WEST SUSSEX COUNTY COUNCIL CONSULTATION

TO:	Arun District Council FAO: Stuart Corbey
FROM:	Highways, WSCC
DATE:	23/11/2018
LOCATION:	110, Southfields Road, Littlehampton, West Sussex, BN17 6PD
SUBJECT:	LU/269/18/HH Vehicular access & hardstanding to front garden.
DATE OF SITE VISIT:	
RECOMMENDATION:	☒ Advice ☐ Objection ☐ Modification ☐ No Objection ☐ More Information ☐ Refusal
S106 CONTRIBUTION TOTAL:	£N/A

REF LU/269/18/HH

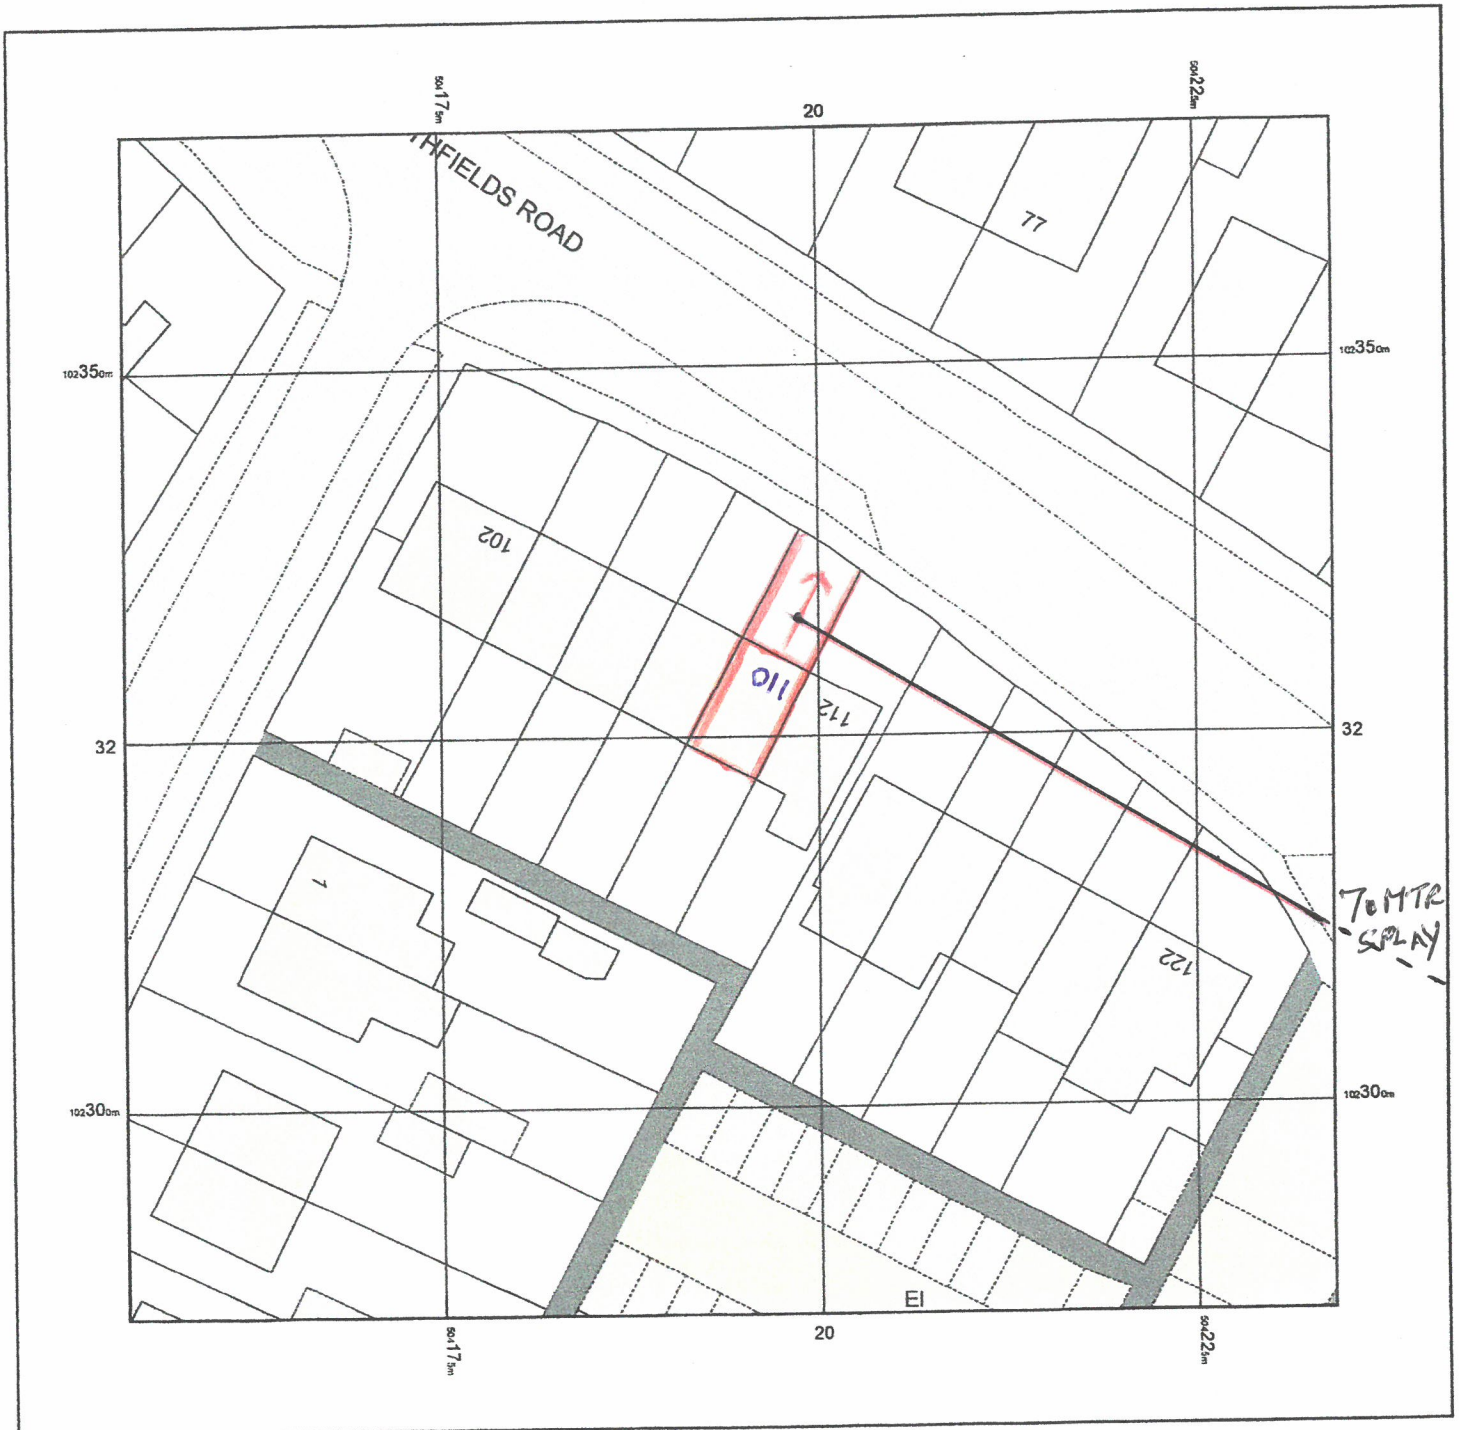
Visibility has been drawn incorrectly. Splays should be drawn from the back edge of the kerb and span from 2.4m back into the access. From observation of WSCC Mapping, the verge and footway at this point measures in excess of 2.4m and the splays are obtainable wholly within the highway boundary. Therefore visibility is not required to be conditioned alongside this application.
